Appendix Q-3 – Details of Refinements to the Proposed Scheme – Refinements at the MIND Centre and Grounds

Great Yarmouth Third River Crossing Further Consultation on Scheme Proposals at the Community Roots at Mind Site Briefing Note to Accompany Drawing No's PKA018-MP-106 and PKA018-MP-107

6 – Mind Centre and Grounds

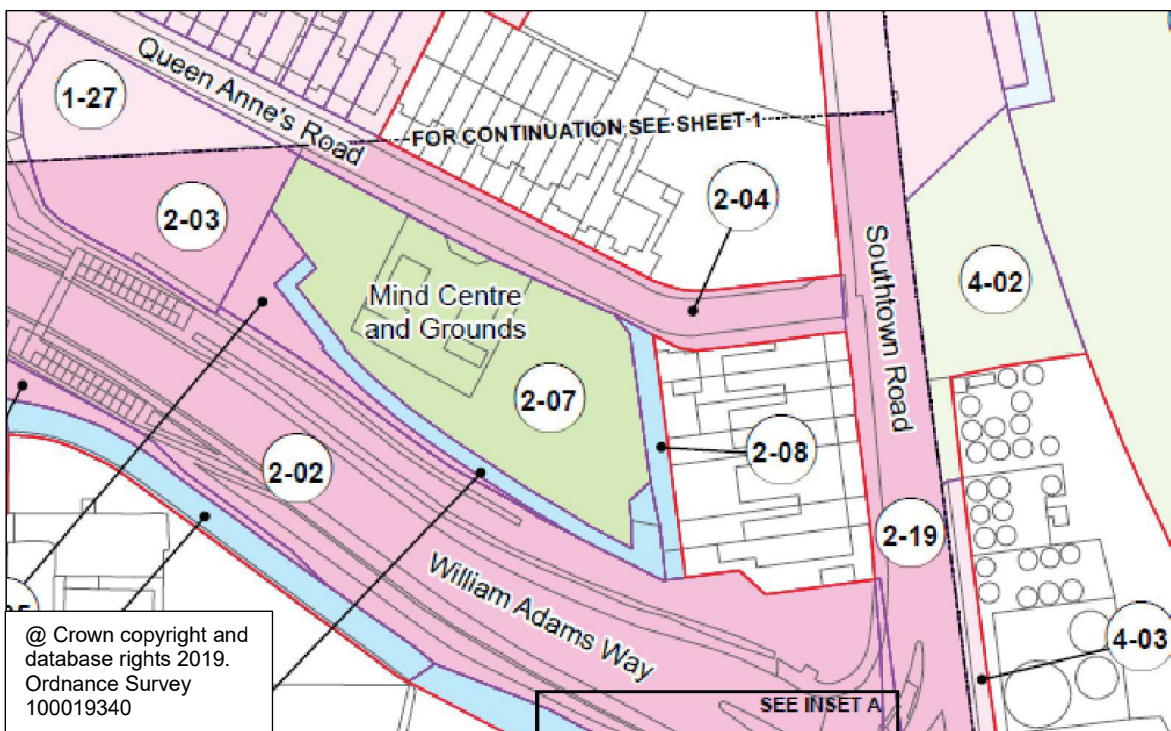
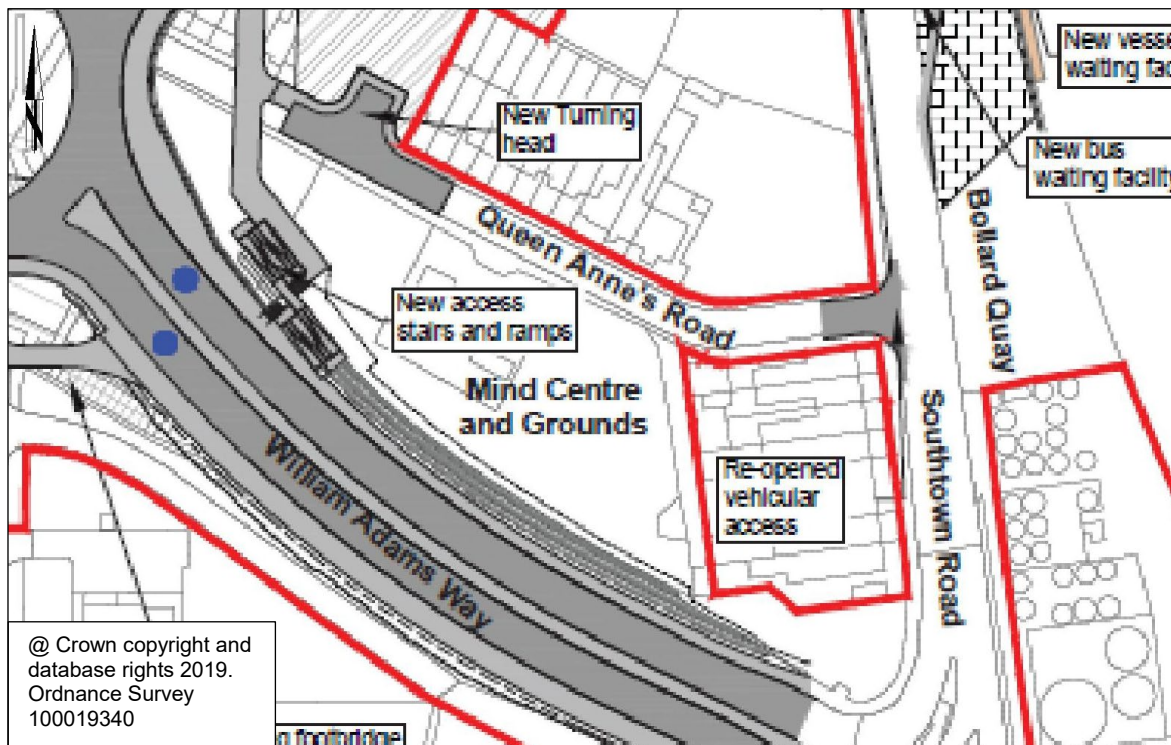
The hatched area shows an updated Scheme boundary that the Council is now consulting upon. This reduces the impact of the Scheme proposals on the Community Roots at Mind site and provides for a greater area for the main site to be retained compared to that previously proposed. The increased site area would be achieved by:

- Removing the originally proposed drainage ditch on the south side of the site, together with changing the terraced embankment slope between William Adams Way and the Community Roots at Mind site. A typical cross section showing this terrace slope is provided on the drawing (see Cross Section X-X). The slope could be planted as part of the Scheme proposals and, subject to agreement, could be maintained by Community Roots.
- Changing the position of the vehicle turning head at the end of Queen Anne's Road (see Drawing No PKA018-MP-107), which enables the extension of the main Community Roots at Mind site further to the west.

- (1) To change the location of the vehicle turning head at the end of Queen Anne's Road, to provide a greater area for the main Community Roots at Mind site. However, this proposal does reduce the area provided for the relocated allotment site currently located on the north side of Queen Anne's Road.
- (2) To mitigate the reduction in size of the relocated allotment site (noted in (1) above), an extra area of land is proposed to be provided.

- (3) To use an area of public open space for the relocation of the labyrinth that currently occupies an area of the Community Roots at Mind site. If the labyrinth cannot be safely relocated then an option could be to recommission the original artist to recreate the labyrinth at this new location. In order to provide the labyrinth on a level surface a retaining feature will be needed on the southern side of this area (see Cross Section Z-Z on the drawing).

- (4) To relocate the proposed footway closer to the roundabout to provide a separate area for the orchard and individual planting areas that are currently on the Community Roots at Mind site.

- (5) To provide a retaining feature on the western side of the roundabout. This is because the separate area for the orchard and individual planting areas will be at the same level as the main Community Roots at Mind site, but the roundabout is approximately 2m higher. A typical cross section through this area is provided (see Cross Section Y-Y on the drawing).
